Planning Application Ref: AW/322/19/T

Location: Strawberry Cottage, Cypress Way, Aldwick, PO21 4DF

Description of works: Reduce laterals on northside away from property by 2-3m to 1no. field maple tree. Reduce 2 tops height by 6m and remainder limbs up to 2m to match and deadwood 1no. oak tree

REF 1

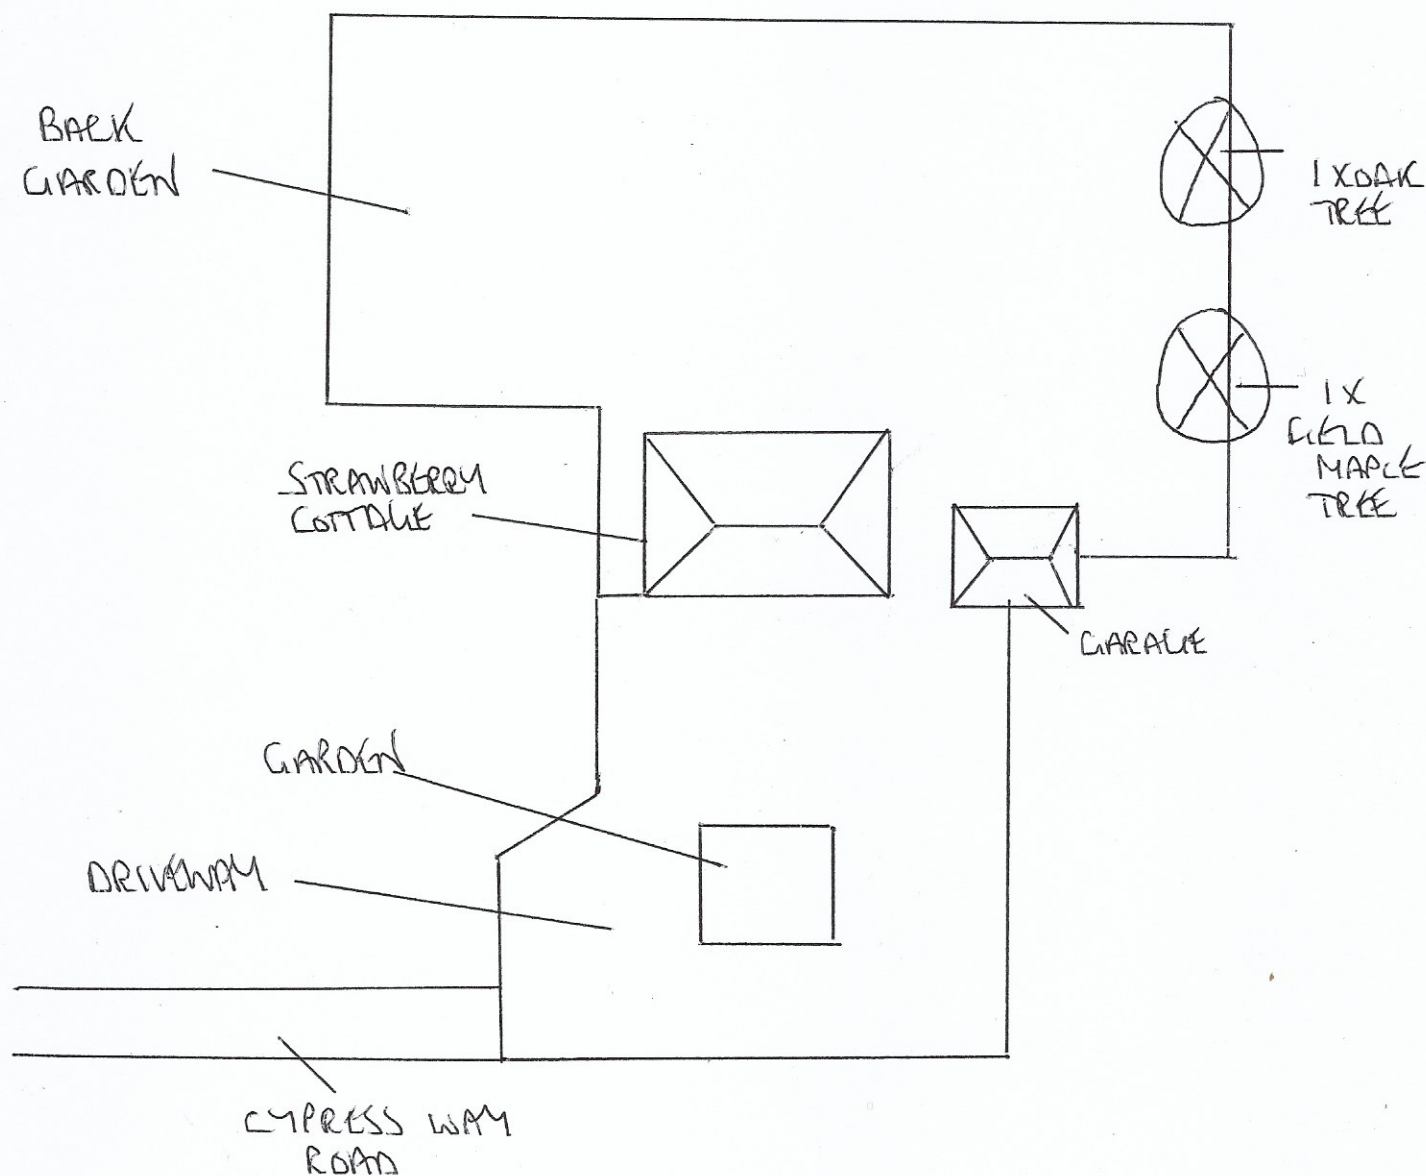
- The multi-stemmed oak has lost a large portion of its dominant central leading stem, from which a healthy quantity of epicormic growth has established. Small branches and twigs growing from outer limbs display low-moderate density of shoots/buds. The crown profile is open, irregular and would benefit from a slight reduction to encourage balanced canopy renewal and greater visual amenity.

- The group of five field maple are an attractive feature, that rely on each other for mutual support. The northernmost tree is the obvious and intended subject of the application, being nearest to the dwelling.

- All work proposed is justified on arboricultural grounds. These are prominent trees of public and visual amenity and are to be carefully pruned to maintain reasonable enjoyment of residential property and with respect for natural tree form.
- **Oak TPO ref. T-269**
If the work is undertaken to a good standard and at the right time; then it is unlikely to have an adverse effect on the tree's long-term vitality.

Part a) Where whole branches are to be removed and final cuts made close to the trunk or branch union they are to be made as shown in Figure 2 of BS3998:2010

Part b) Where branches are to be shortened back the final cuts are to be made at the correct angle shown in BS3998:2010 and adjacent to a live bud or lateral.

The removal of crown material which has developed since the last operation must be done sympathetically and with respect to established 'knuckles' so as not to extend beyond the point of origin.

Part d) The long-term vitality of both trees is best respected when significant pruning work such as proposed, is undertaken during either the late-spring to summer (May to August) or mid-winter (late-December to early-February) periods. The work must only be undertaken during these periods.
